Our Ref: FP/153/20/NMA

**Section 96A of the Town & Country Planning Act 1990 (as amended)
Town and Country Planning (Development Management Procedure) (England) Order 2015 (as amended) - Article 10**

Non material amendment following grant of FP/46/19/PL for addition of window on east elevation.
28 Sea Drive Felpham PO22 7NE

Dwg Reference:
Elevations as proposed

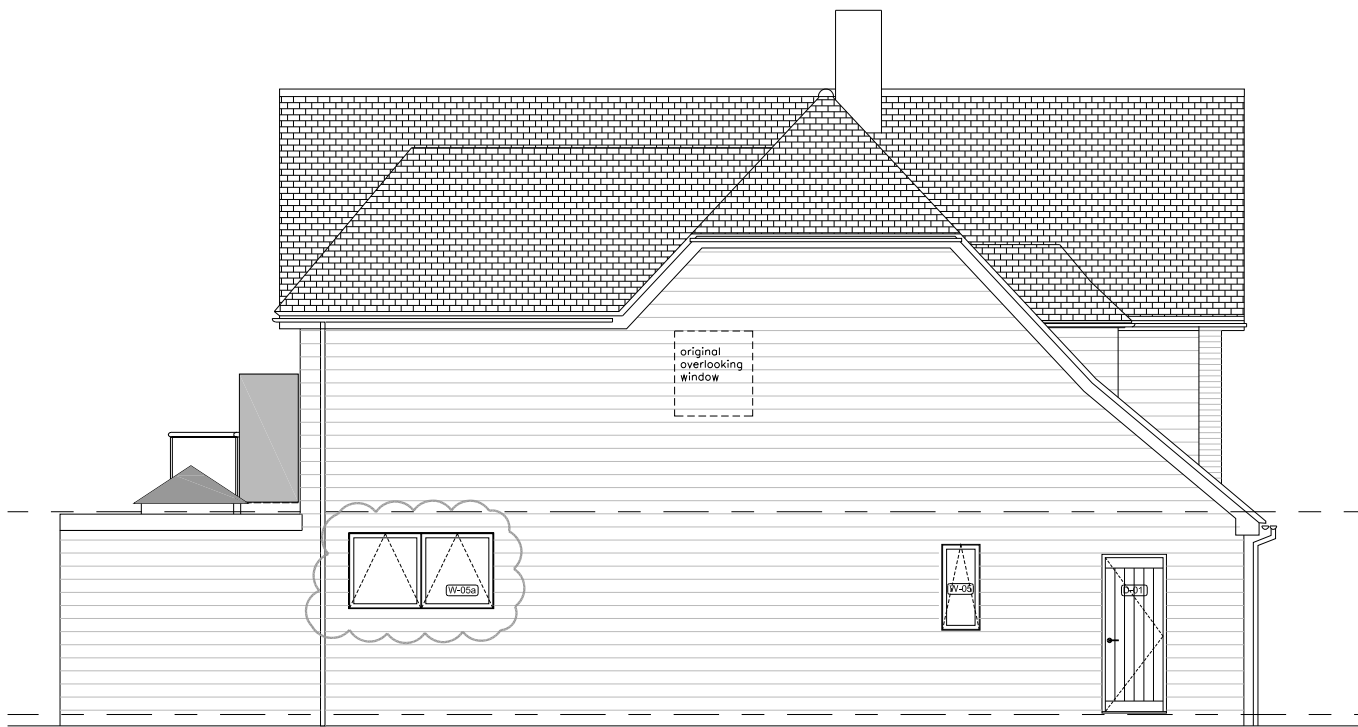
The reasons that these proposals have been accepted as Non-Material Amendments is because it does not have a material impact upon the originally approved development and do not necessitate additional consultation. At ground floor level the window is not considered to give rise to additional overlooking with boundary treatment also in place and it can therefore be considered under section 96A of the Town and Country Planning Act 1990.

Whilst the plans show additional changes relating to a rooflight and balcony alterations, as the description only relates to the addition of a window to the eastern elevation, this is the only change that has been considered and other changes will need to be resolved separately.

- Proposed Ground and First Floor Plan - AGA01 Rev G
- Proposed Elevations - AGA03 Rev F
